OXFORDSHIRE COUNTY COUNCIL'S RESPONSE TO CONSULTATION ON THE FOLLOWING DEVELOPMENT PROPOSAL

Application no: 21/03913/F

Proposal: Planning Application for Development within Use Classes E (g) (i), and/or (ii), and/or (iii), and/or B2 and/or B8 and associated works including access and parking

Location: Unit 5B, Oxford Technology Park, Langford Lane, Kidlington

content: BUILDING 5A & 5B
HARD LANDSCAPING SITE PLAN

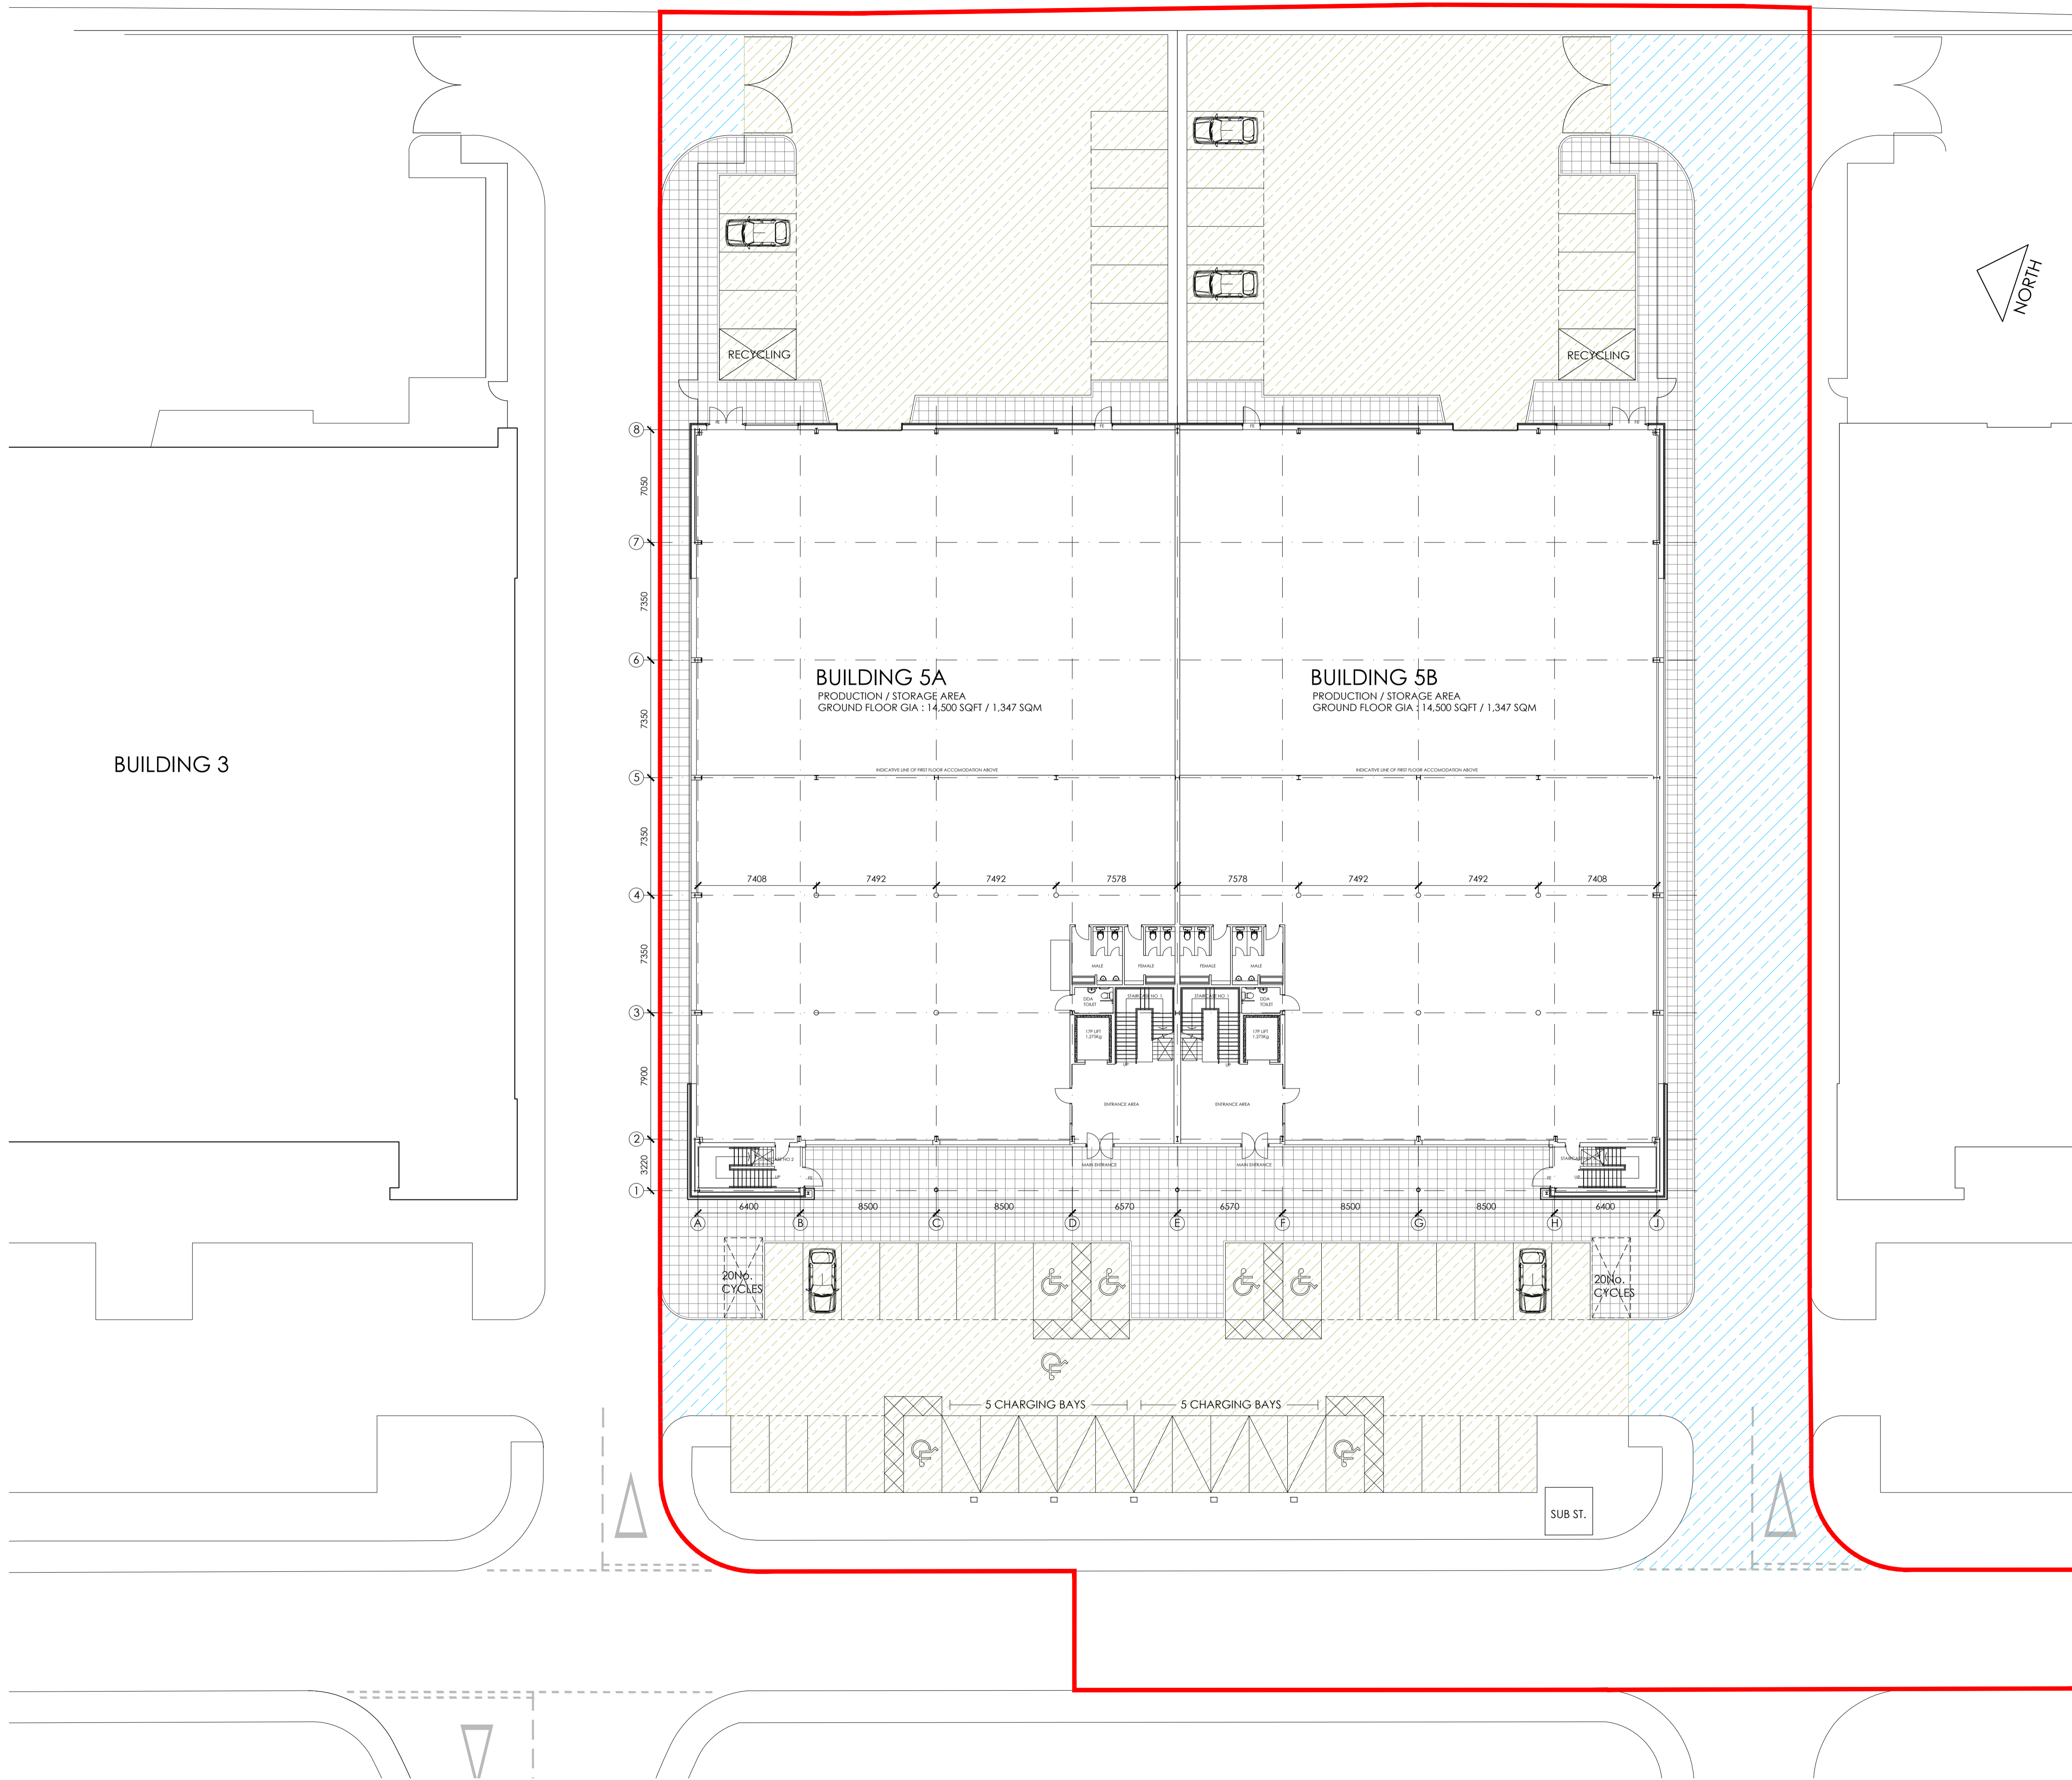
Prior to commencement of the development, a plan detailing the road layout of the car parking area shall be submitted to, and approved by, the Local Planning Authority. The Car Park Layout Plan must set out so that all car parking spaces meet the minimum dimensions required and can be safely and easily accessed.

The proposal will include 60 car parking spaces including 6 disabled parking spaces and 10 EV charging spaces. Using the OCC Parking Standards for B1 and B2 class use of 1 space per 30 sqm and 1 space per 50 sqm, the TA puts the maximum parking proposal at 114 parking spaces. Given OCC's policy on provision of electric Vehicle charging points, the Applicant should increase the proposed EV parking spaces to 15 space with some allocated to the designated disabled parking bays.

content: BUILDING 5A & 5B  
PROPOSED CYCLE LOCATIONS

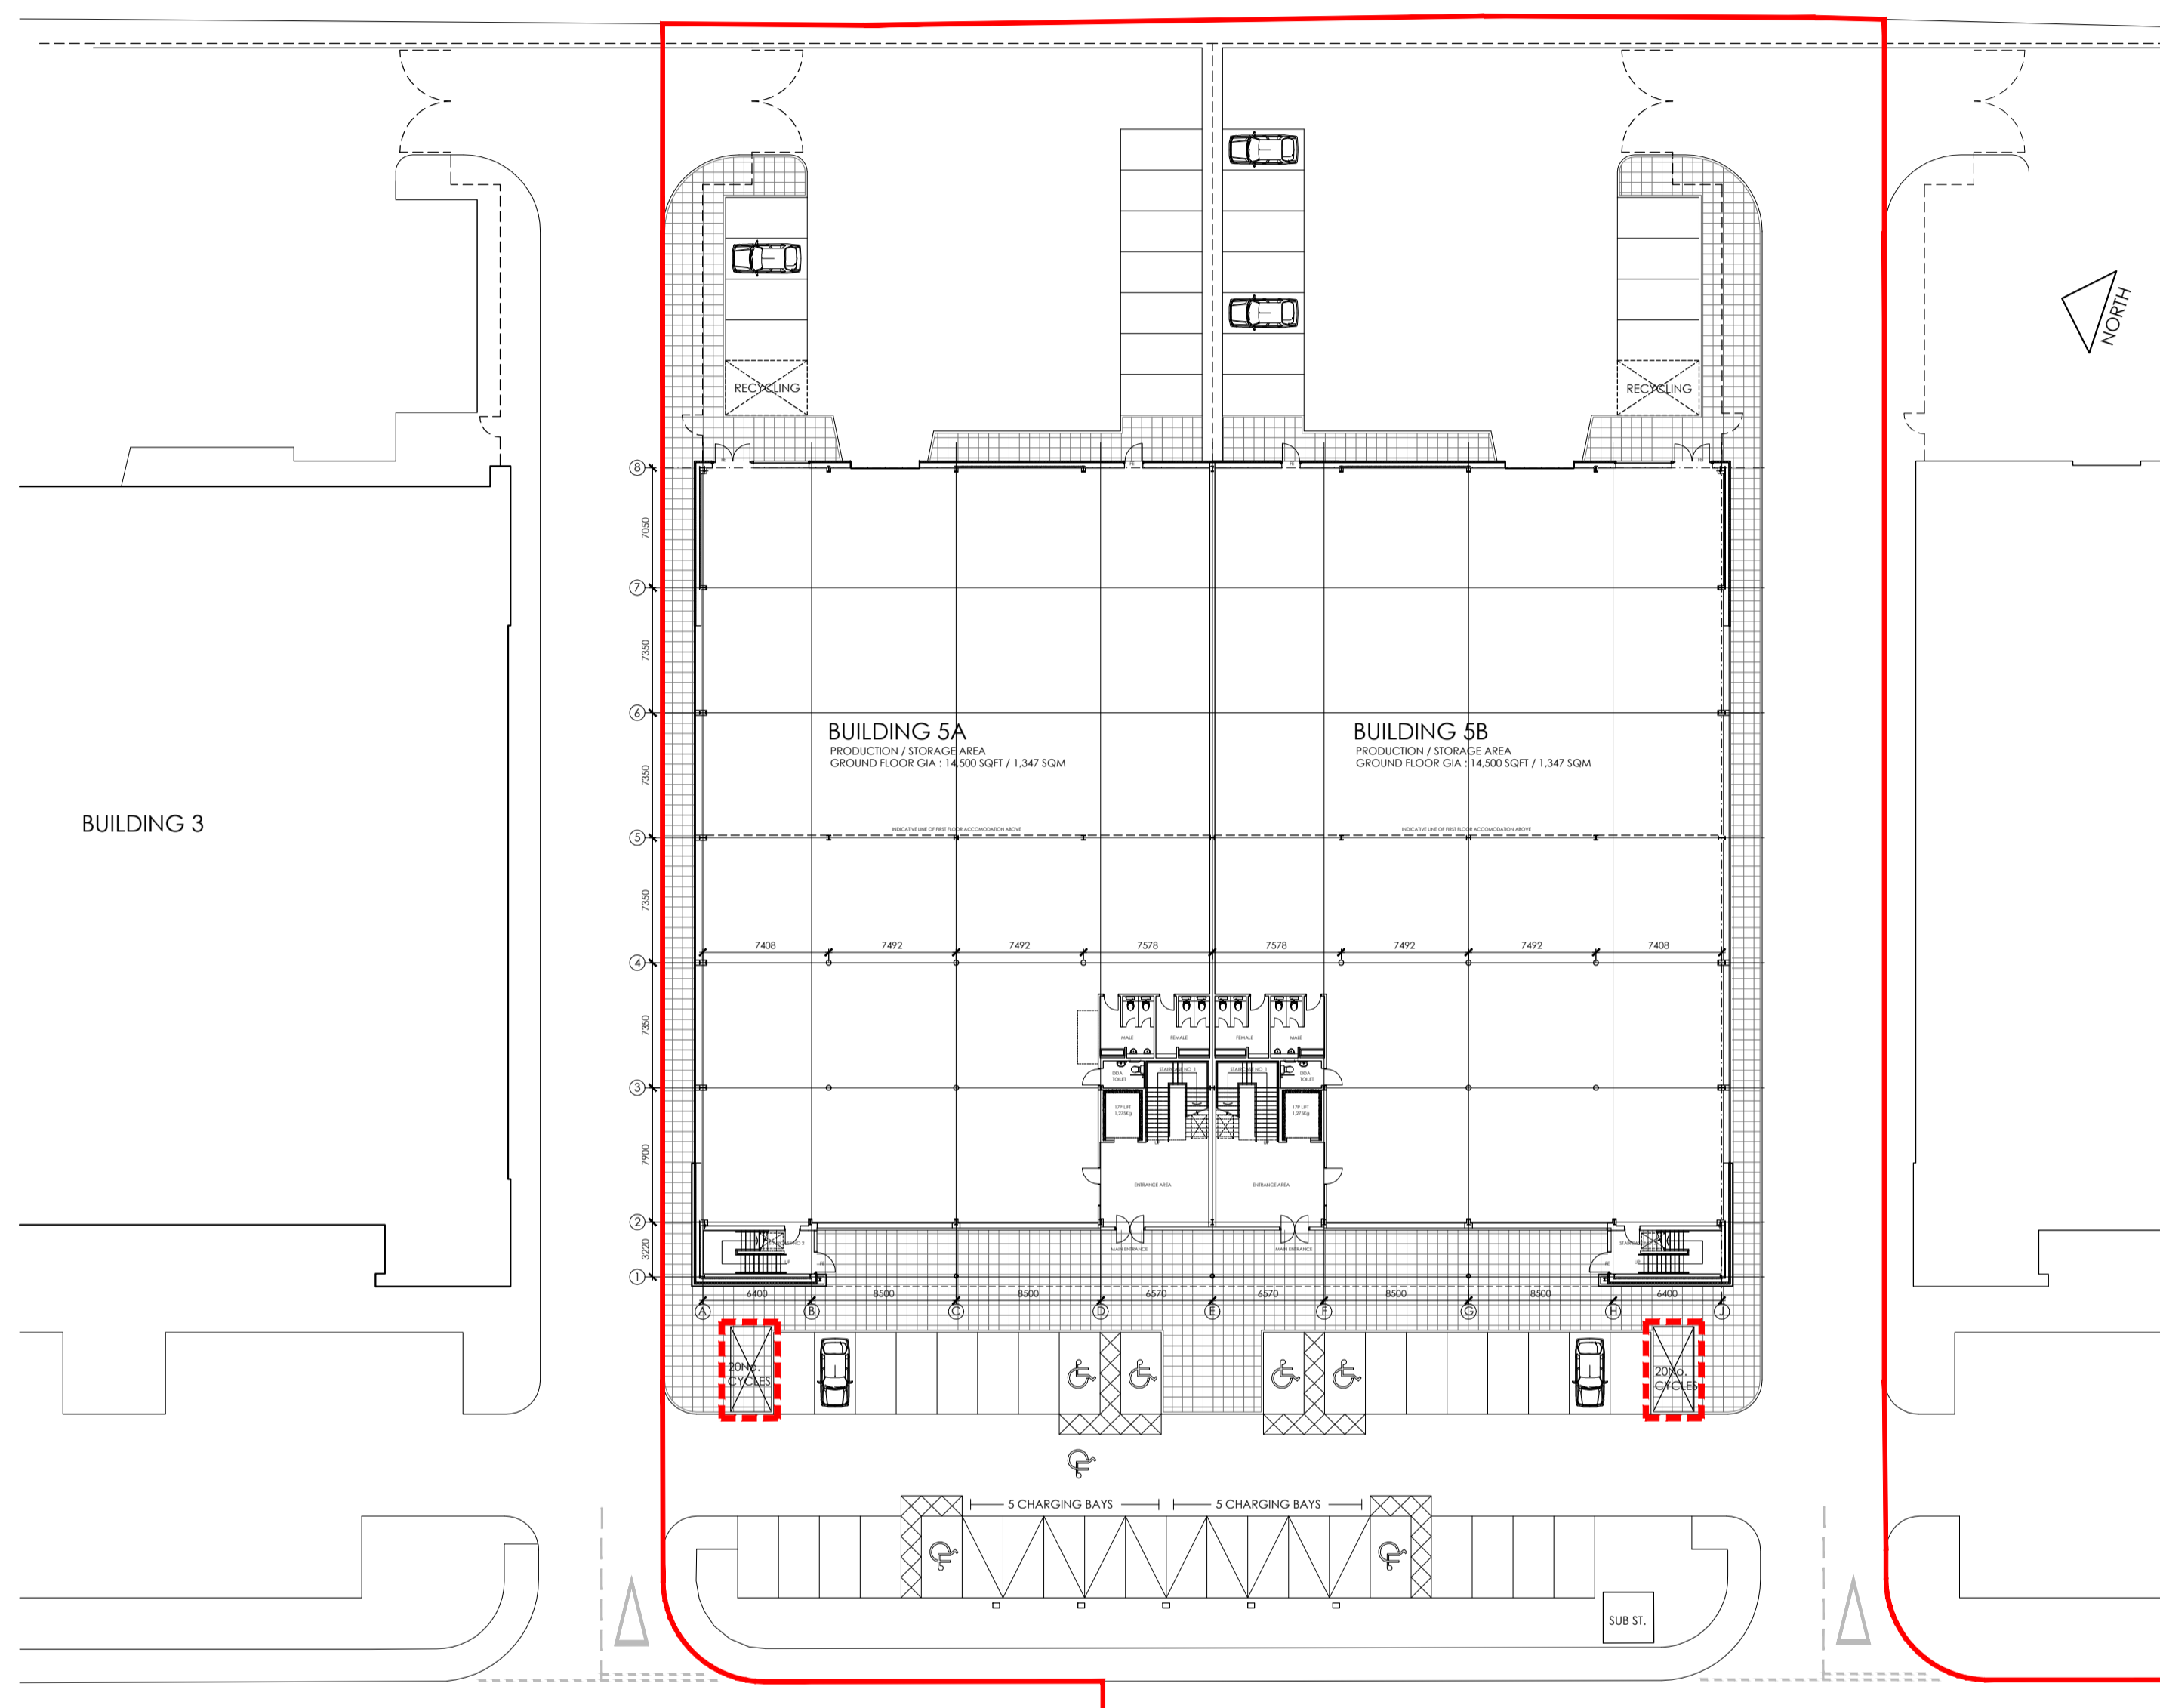
The TA confirms that, a footway/cycleway is required as part of the Phase 1 employment site and the links into the wider road and footway network will be made permanent as part of the proposed Phase 3 development; cycle storage areas are shown on the submitted plans, however there are no details of cycle storage facilities in support of the Application.

Before the development occupied is details of the cycle parking areas, including dimensions and means of enclosure, shall be submitted to, and approved in writing by, the Local Planning Authority. The development shall not be brought into use until the

cycle parking areas and means of enclosure have been provided within the site in accordance with the approved details and thereafter the areas shall be retained solely for the purpose of the parking of cycles.
